CITY OF ALBUQUERQUE

October 7, 2016

Re: Clean Machine Car Wash
6016 Central Ave. SE
Traffic Circulation Layout
Engineer's/Architect's Stamp 09-15-16 (K18-D079)

Based upon the information provided in your submittal received 09-15-16, the above referenced plan cannot be approved for Building Permit until the following comments are addressed:

SHEET NO:
C101

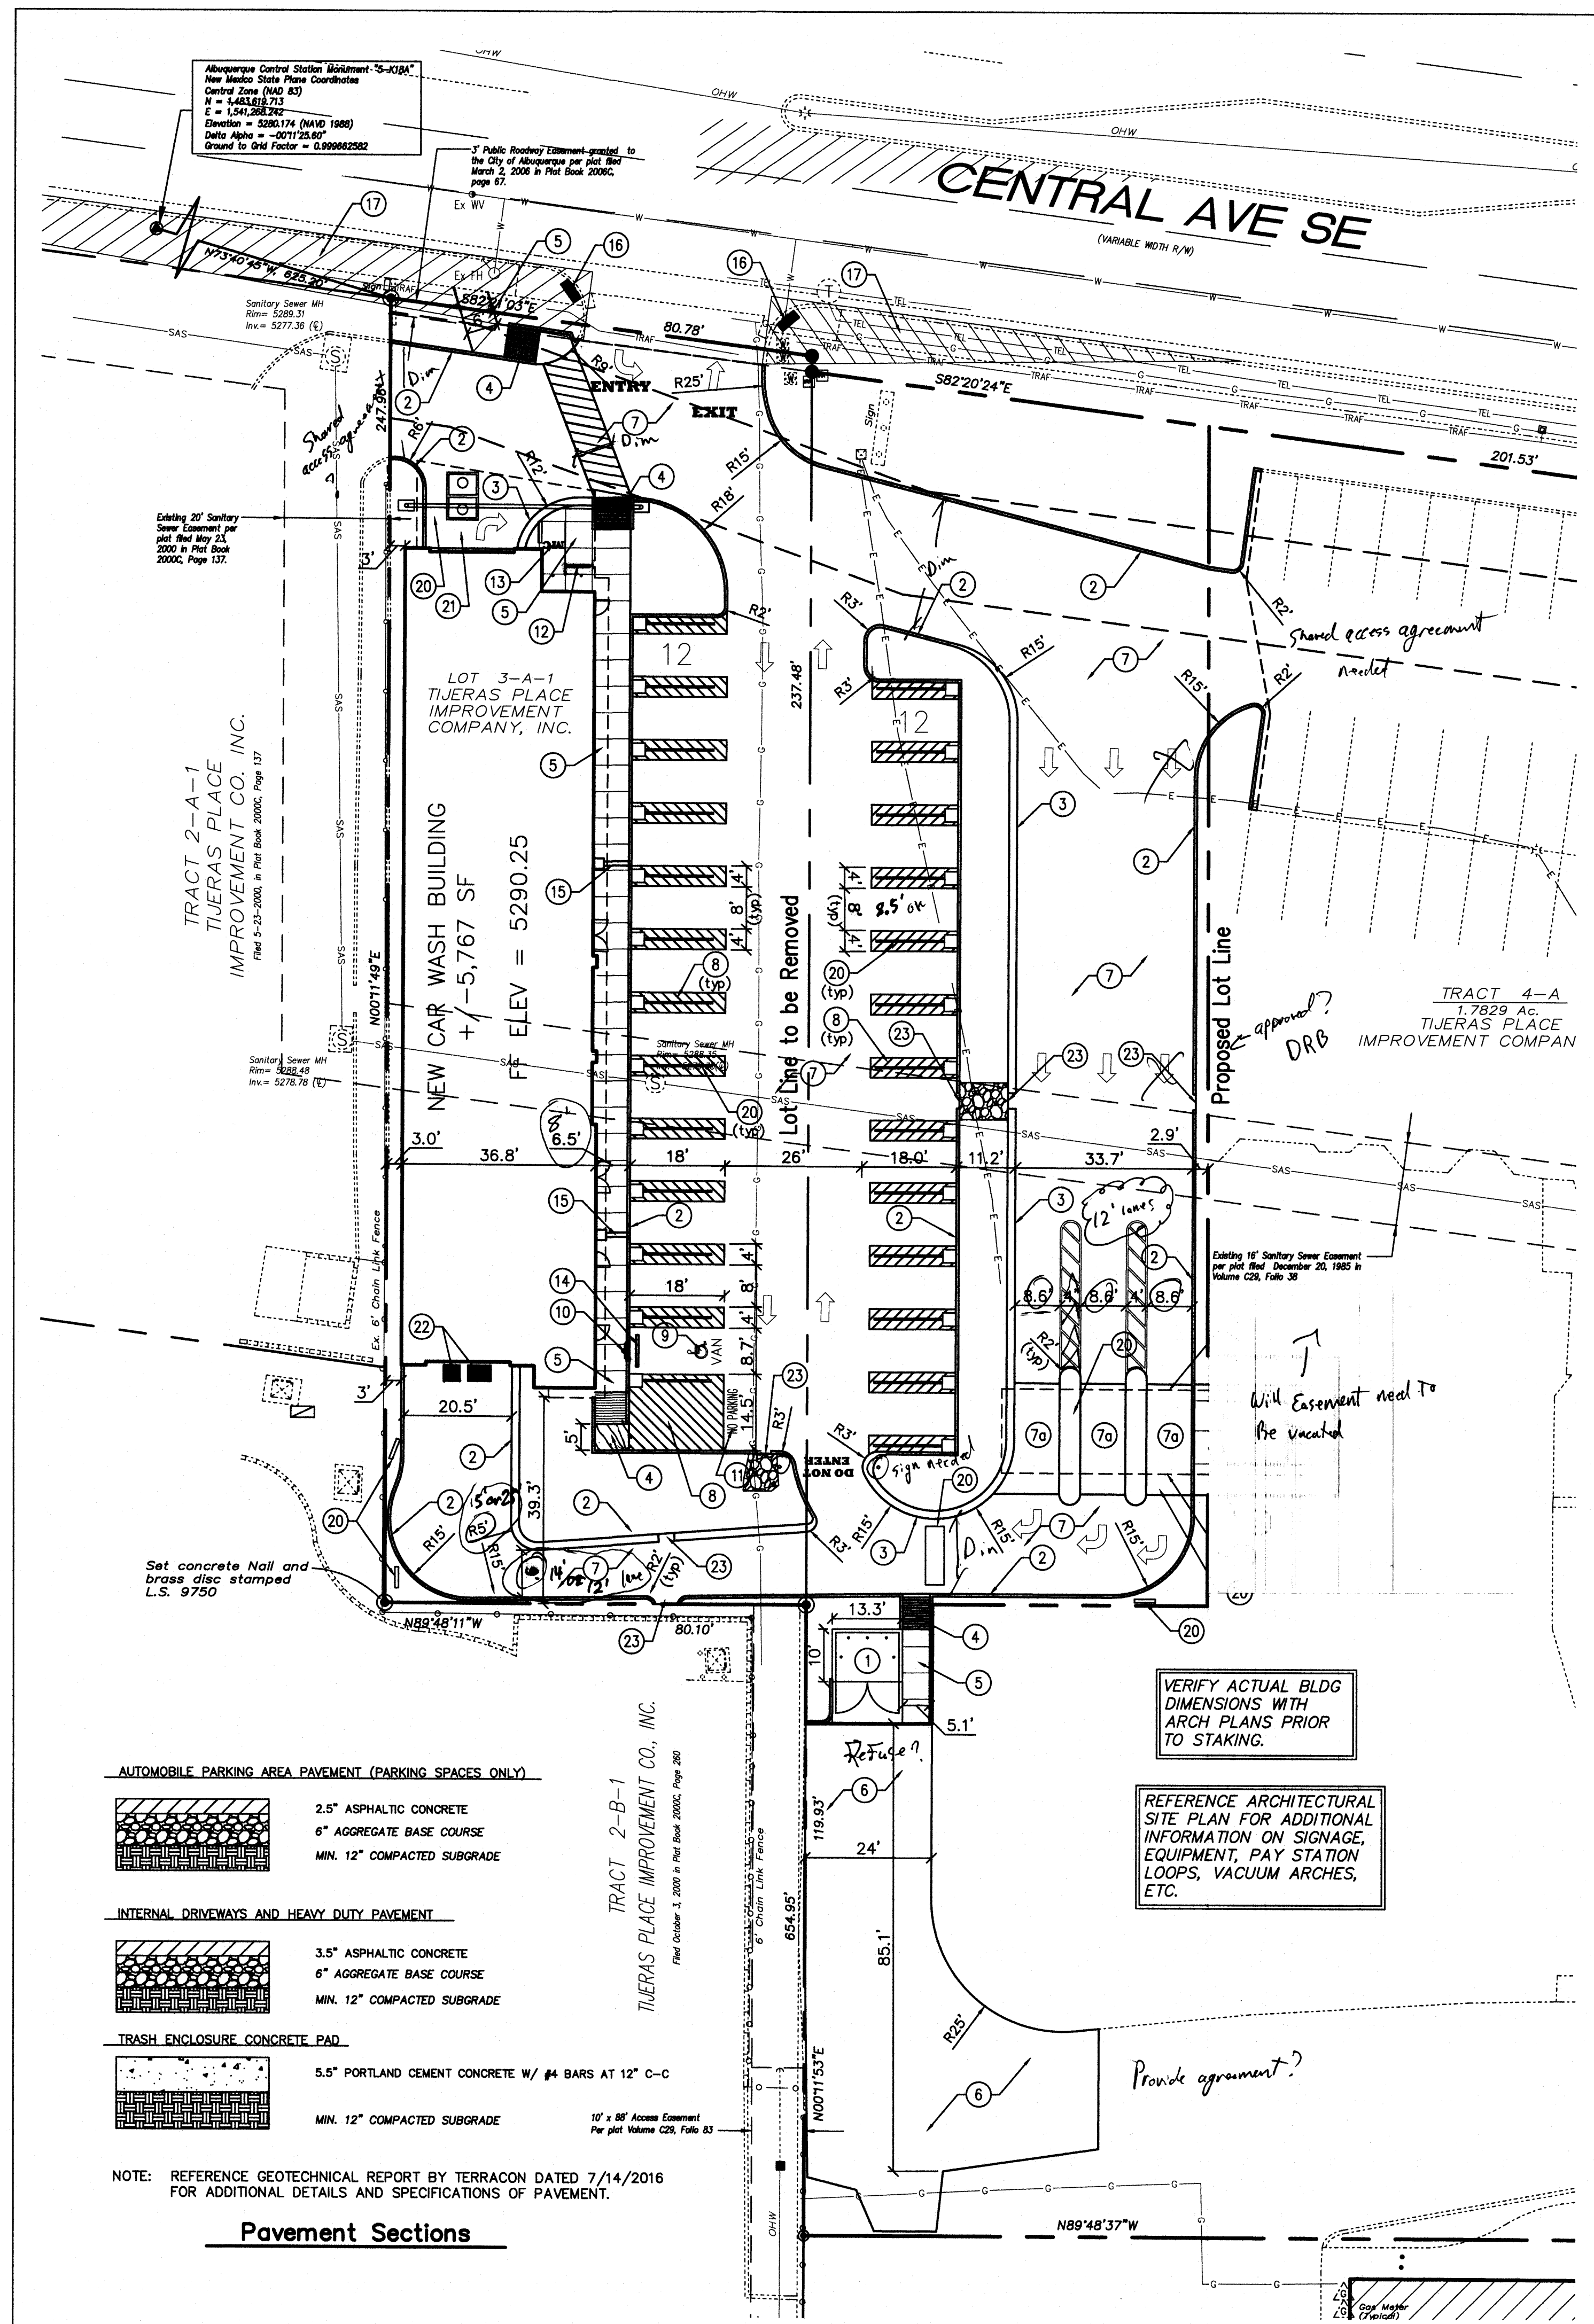
1. Identify all existing access easements and rights of way width dimensions.
2. Identify the right of way width, medians, curb cuts, and street widths on Central.

3. Clarify existing property lines and proposed property lines.
 - DRB approval is required for proposed lot line and removal.
 - Provide shared access/access agreements for the refuse, J.D. Byrider entrance, and parking lot locations.

4. Show all drive aisle widths and radii. Some dimensions are not shown. Minimum lane widths are 12 feet minimum with a 25 foot minimum radius (inside edge) for all turns. (A 15 foot radius can be used with an increase in lane width to 14 feet).

5. A 5 ft. keyway is required for dead-end parking aisles.
6. Per the zoning code, a 6 ft. wide ADA accessible pedestrian pathway is required from the public sidewalk to the building entrances. Please provide details and dimensions.

7. Provide a min 6" or max 8" high concrete barrier curb or other acceptable barrier between landscaping and parking areas and/or drive aisles. Please call out detail and location of barrier curb. Parking areas shall have barriers which prevent vehicle encroachment and which shall be located two feet from any pedestrian walkway or landscaped area.

8. Service vehicle and/or refuse vehicle maneuvering must be contained on-site; provide a copy of refuse approval.
9. One-way vehicular paths require pavement directional signage. Please show detail and location of posted signs.

10. Work within the public right of way requires a work order with DRC approved plans.
11. Pedestrian path in front of building will need to be eight (8) feet per zoning code.
